Application Reference: 6/2019/1338/NMA

Proposal: Non material amendment for the installation of fascia panel along perimeter of roof on north and east elevations on planning permission 6/2019/1338/FULL

Location: University of Hertfordshire, Club de Havilland, Hatfield, AL10 9EU

UOHS-KSS-DH-ZZ-DR-A-1303

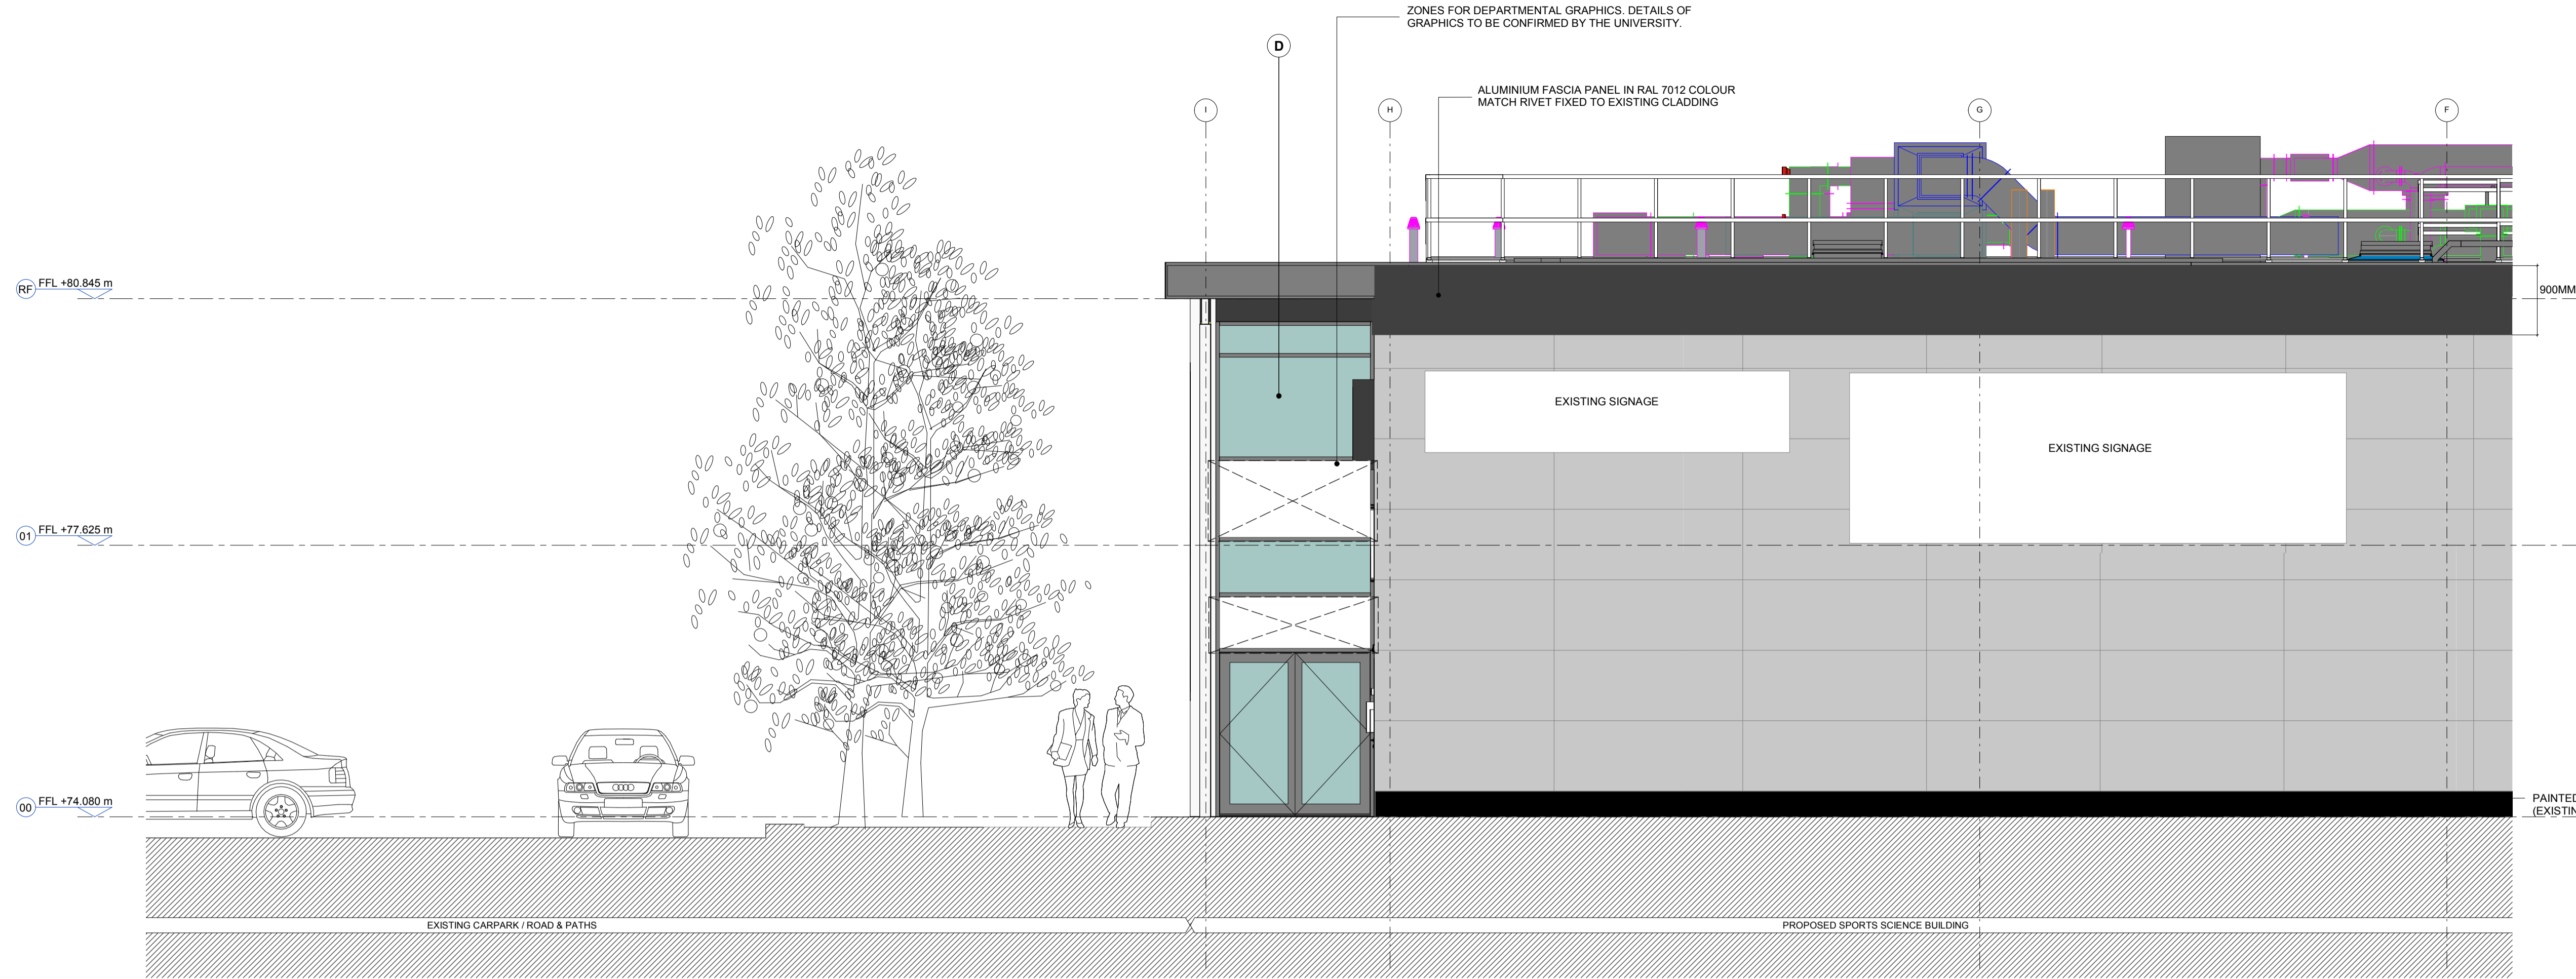
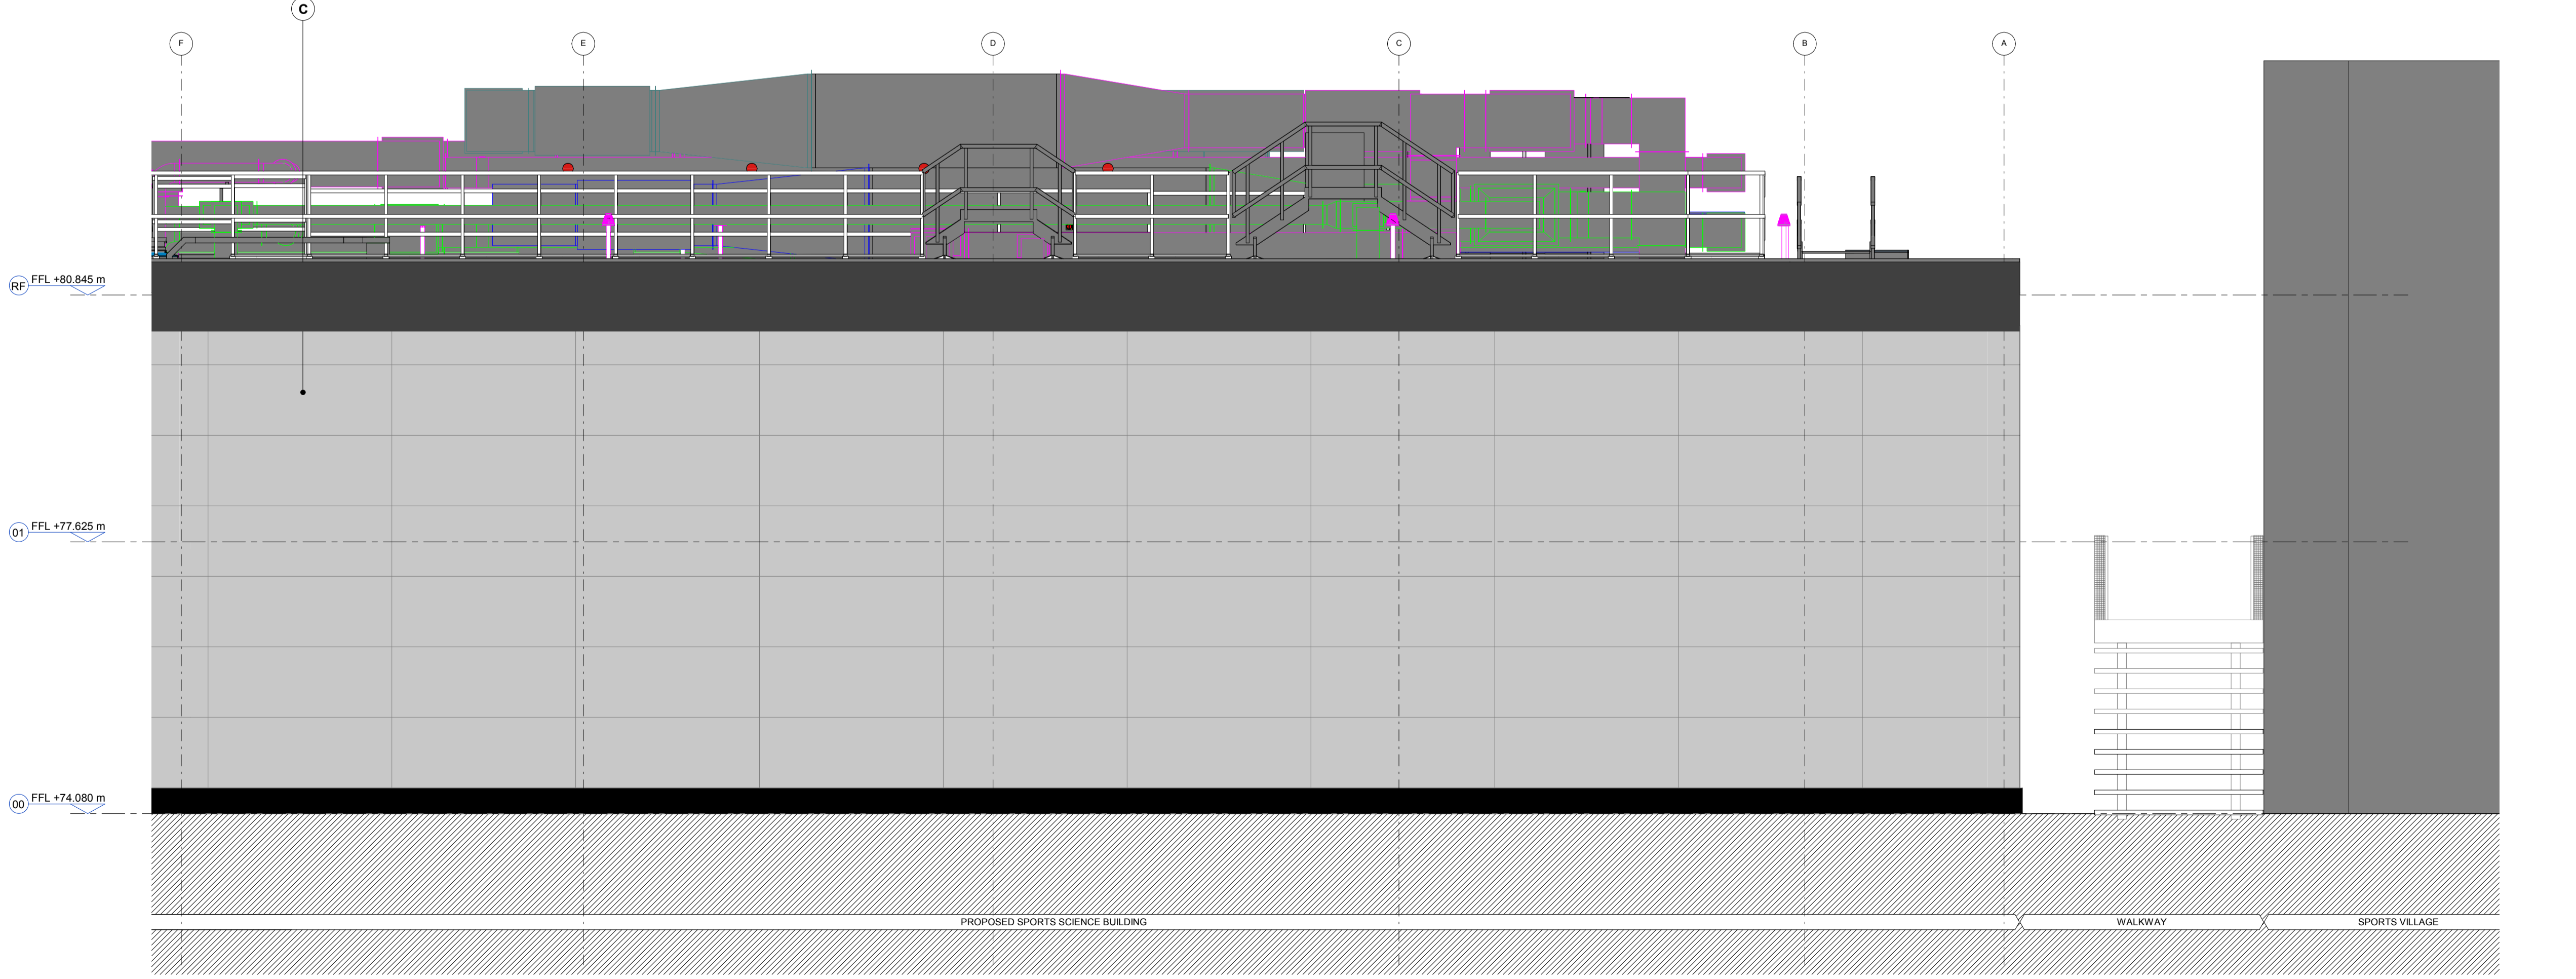
The proposed amendments are considered to be minor in relation to the original approval; the resulting scheme would not alter the nature or description of the development; the amendments would not result in a detrimental impact on the appearance of the development or the wider character of the area; the amendments would not have any additional impact on the residential amenity of neighbouring properties and would not be contrary to development plan policies.

In conclusion, the Local Planning Authority consider the proposed amendment to be non-material and acceptable in accordance with the submitted drawings:

UOHS-KSS-DH-ZZ-DR-A-1303 Rev C1
